REFUSAL OF PLANNING PERMISSION

APPLICATION NO. 2017/1196

Proposal Retention of beer garden and new car parking spaces to rear of public house
(amended details to application 2015/1162)

At The Cross Inn, 7 Summer Lane, Royston, Barnsley, S71 4SE

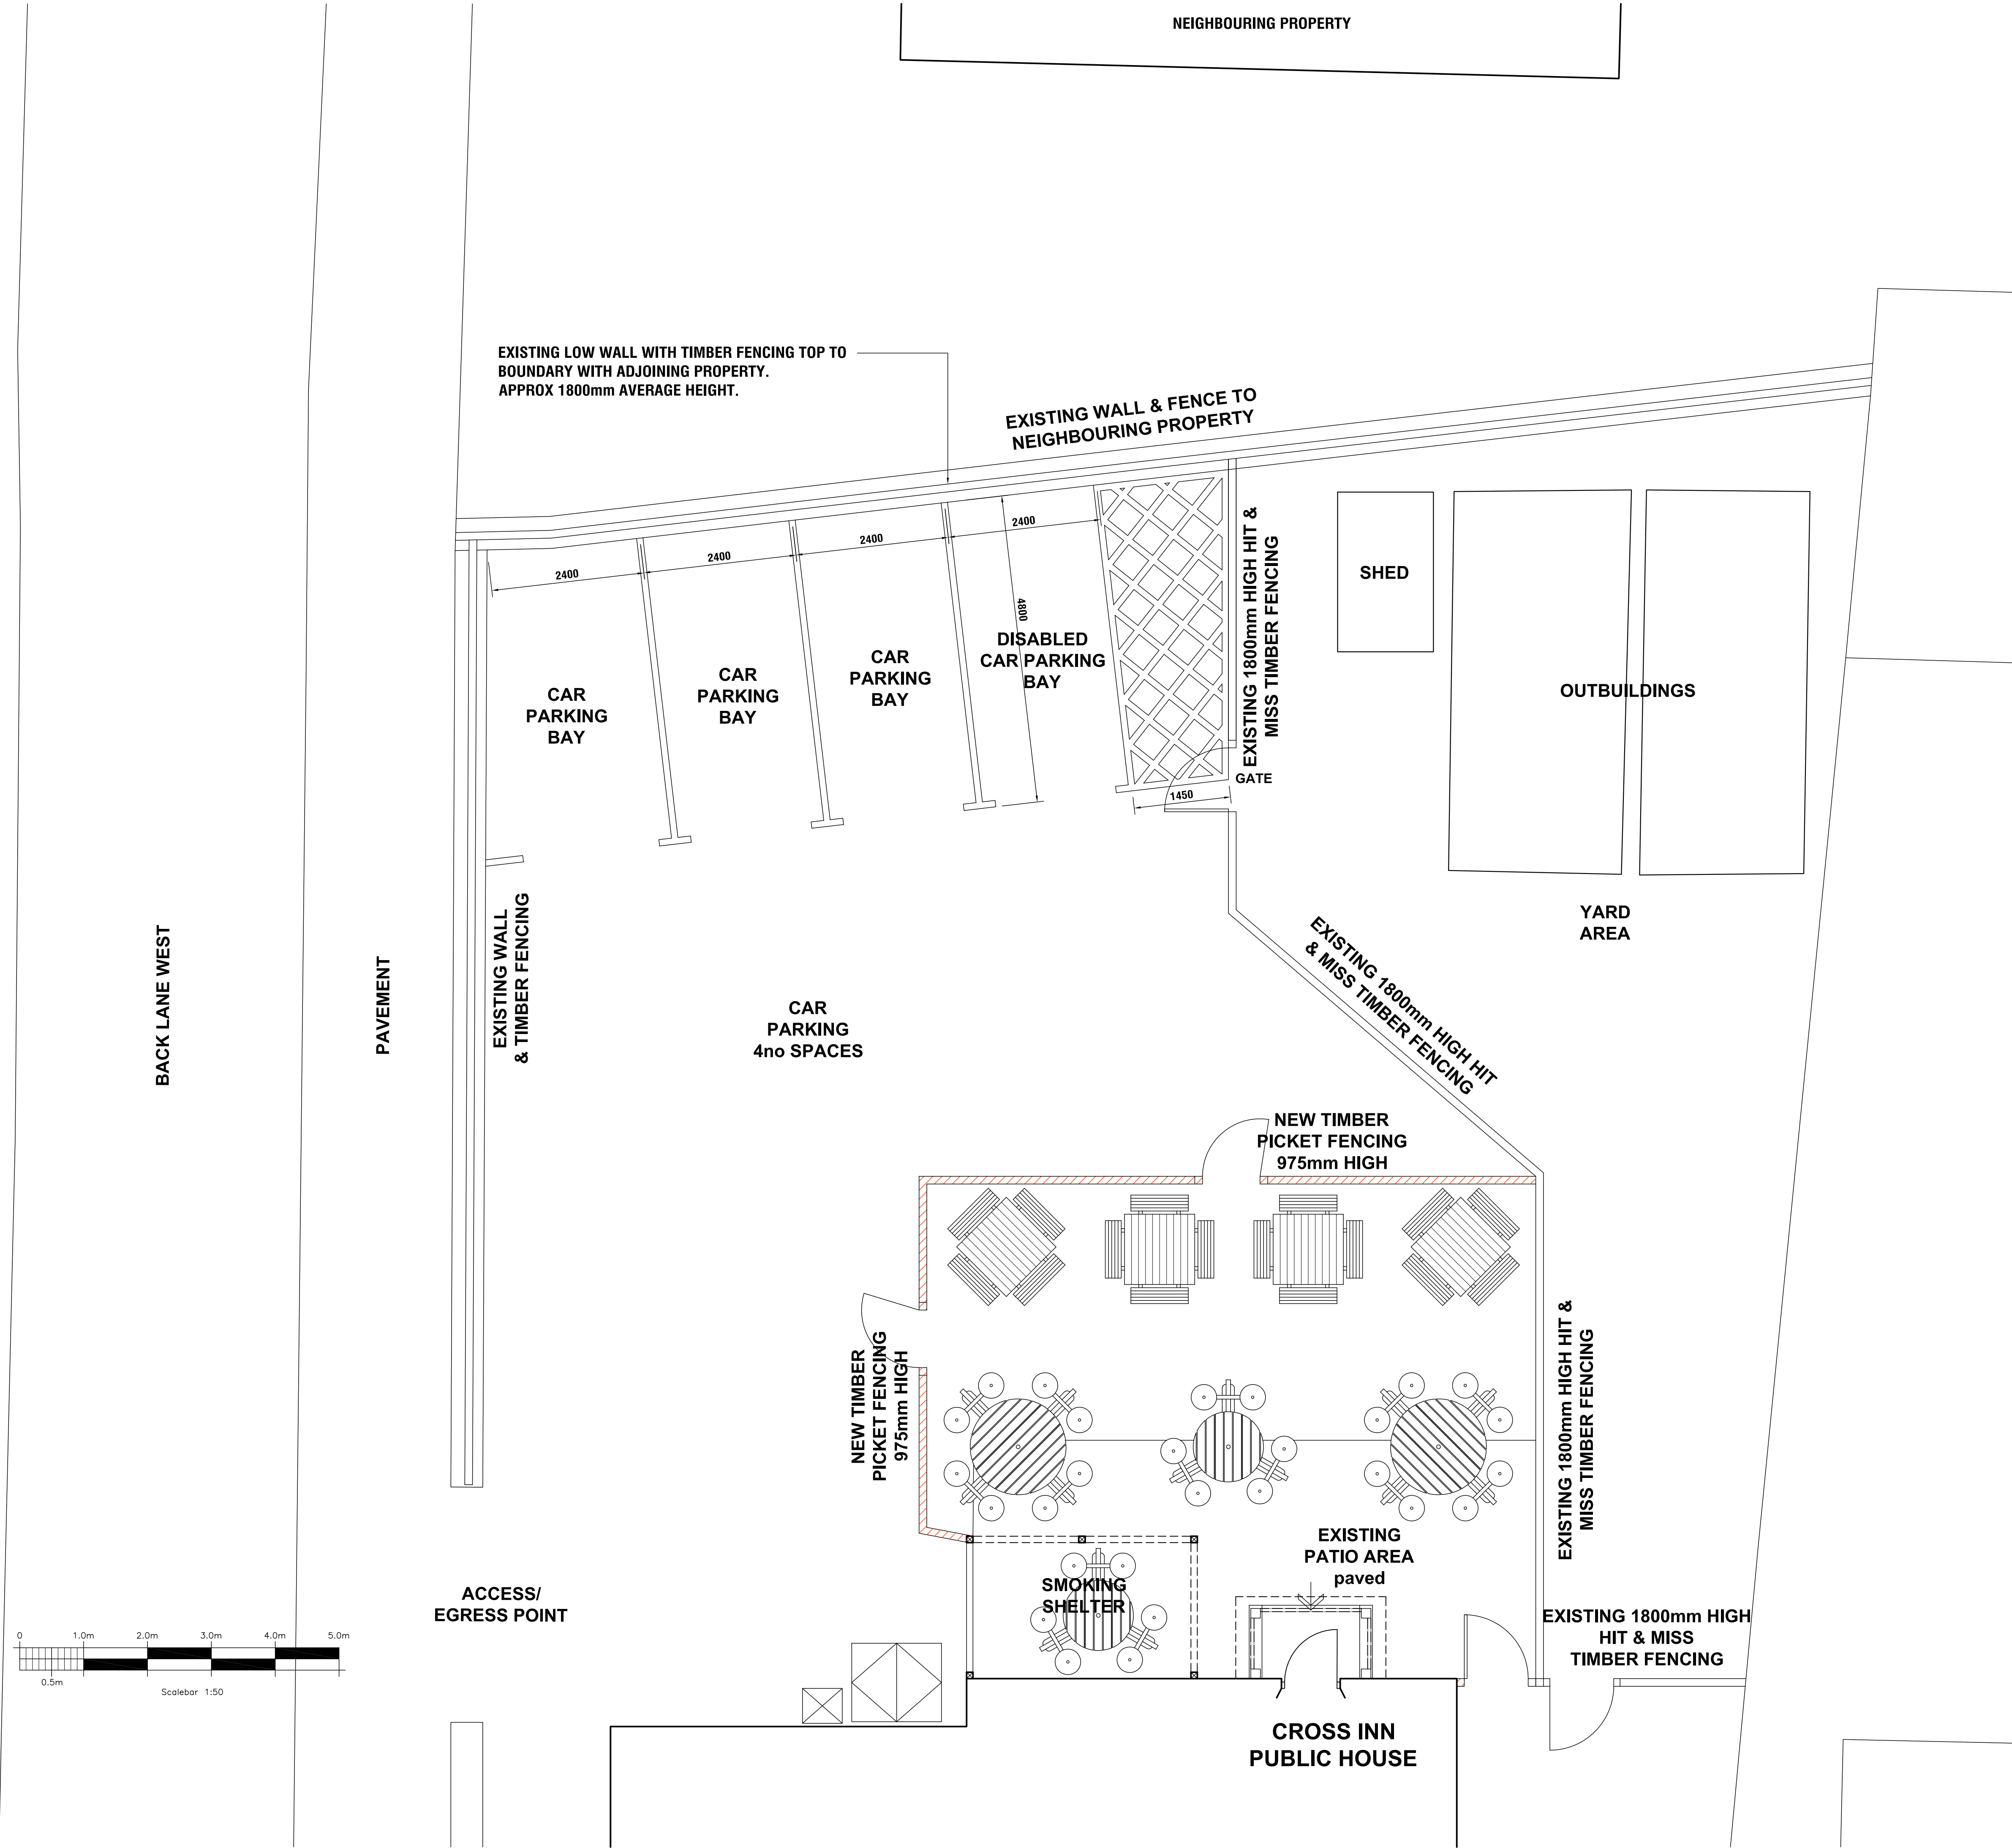
- 1 In the opinion of the Local Planning Authority, the beer garden/patio area is materially detrimental to the amenities of the occupiers of the adjacent properties by reason of noise nuisance and general disturbance. The development is therefore contrary to UDP Policy ED4 'Economic Development and Residential Amenity', Core Strategy Policy 40 'Pollution Control and Protection' and the National Planning Policy Framework.
- 2 The development would result in the loss of some off street customer parking facilities, to the detriment of the free and safe flow of traffic on the highway on the roads outside the pub, which are unsuitable to safely accommodate further on street parking. As such, the development is contrary to Core Strategy policy CSP 26 'New Development and Highway Improvement' and Supplementary Planning Document 'Parking'.
